OUT21/2581

**Cowal Gold Operations Underground Development and Modification 16 (SSD 10367)
Response to Submissions**

Detailed advice to DPIE Planning & Assessment regarding the Cowal Gold Operations Underground Development and Modification 16 (SSD 10367) – Response to Submissions

Proposed monitoring bore locations

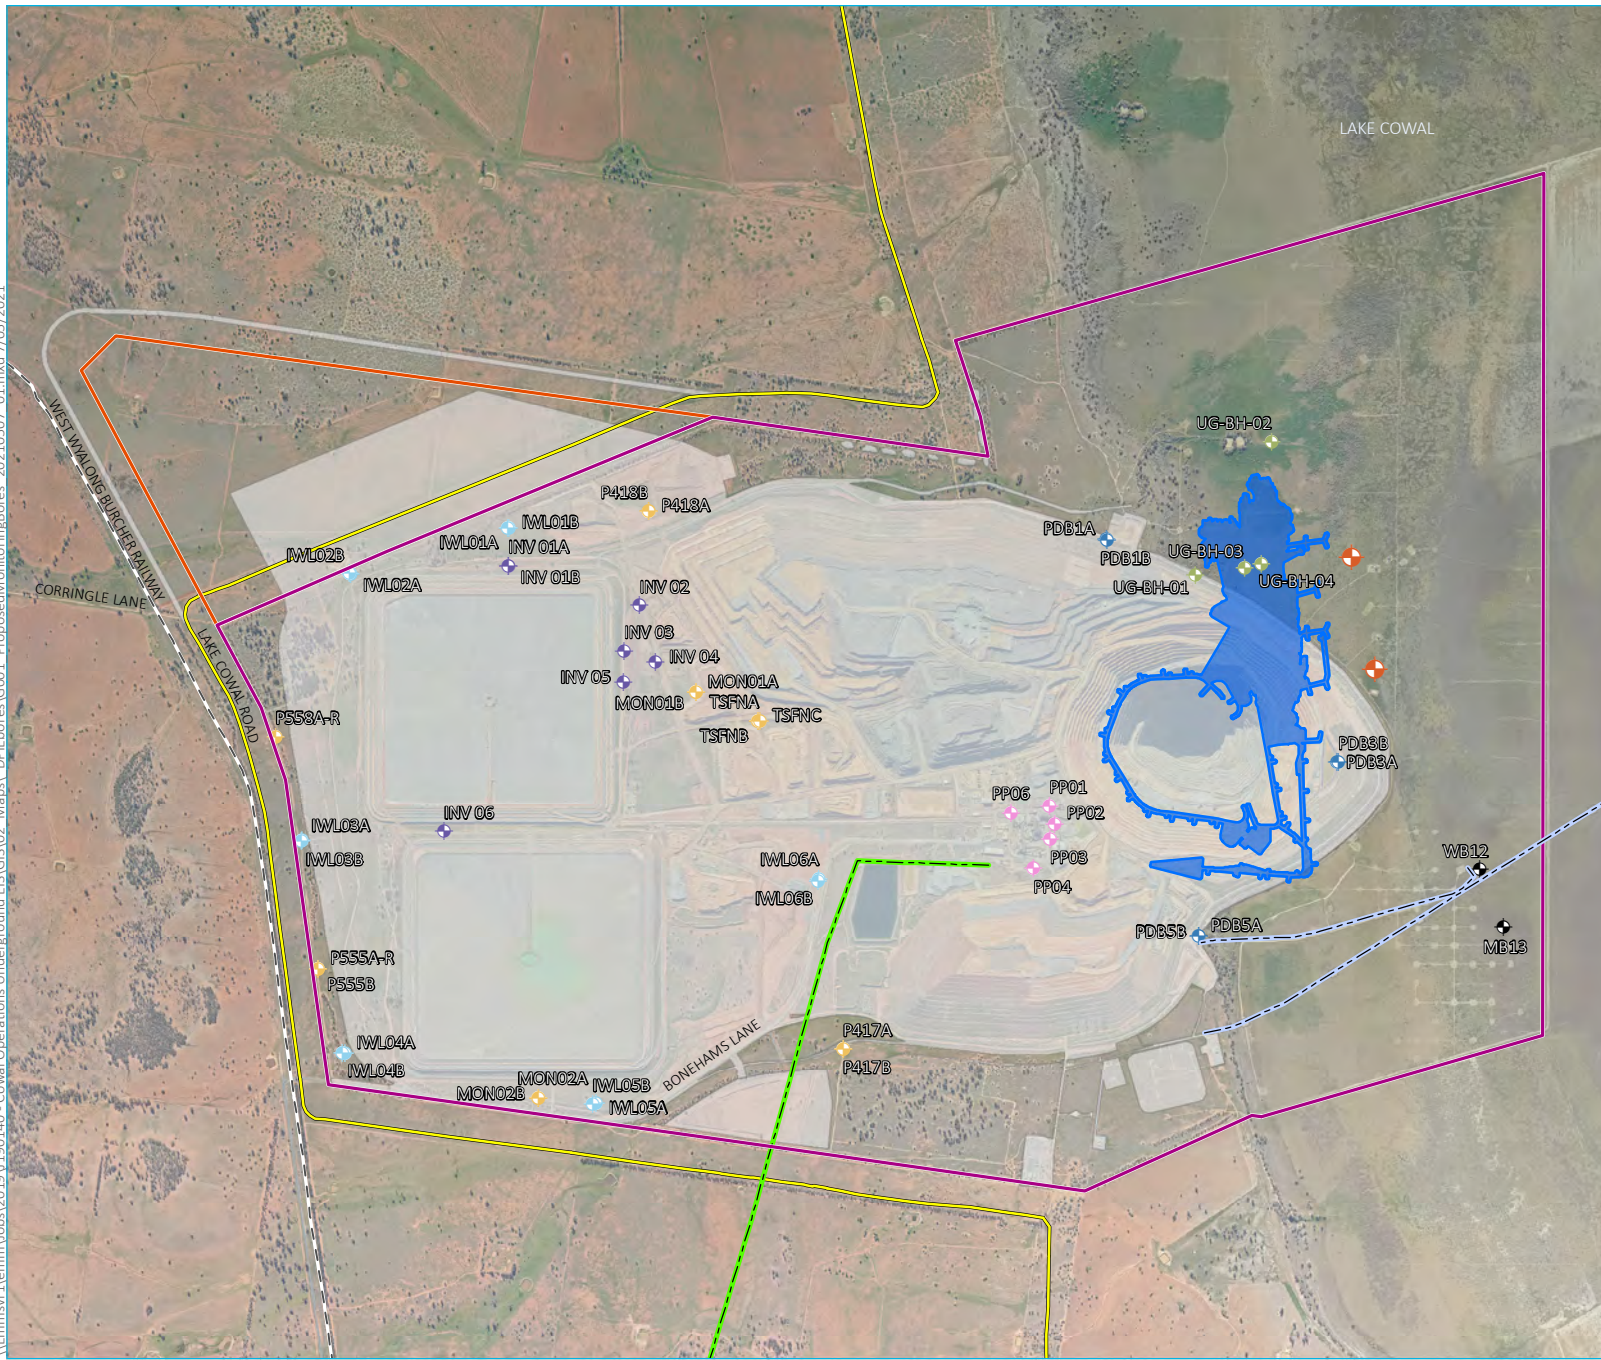
We are generally satisfied with the proponent's response. However, we seek a commitment from the proponent to install a minimum of two nested monitoring bore sites parallel to and adjacent to the proposed underground mine alignment within the mining lease covering Lake Cowal. This is to monitor for any potential impacts as well as provide evidence of the predicted minimal impact on the groundwater table irrespective of whether the lake is full or dry.

- 1 Install a minimum of two nested monitoring bore sites, both with separate pipes which are screened in the alluvium (Transported Unit) and the underlying Lachlan Fold Belt sequence (sapolite/saprock). These are to be installed parallel to and adjacent to the proposed underground mine alignment within the mining lease covering Lake Cowal.
- 2 Maintain and undertake extension to the groundwater monitoring program as outlined in this RtS for the duration of the current and future Cowal Gold Operations. Any extensions or changes to the groundwater monitoring network will need to be reflected in an update to the Water Management Plan.
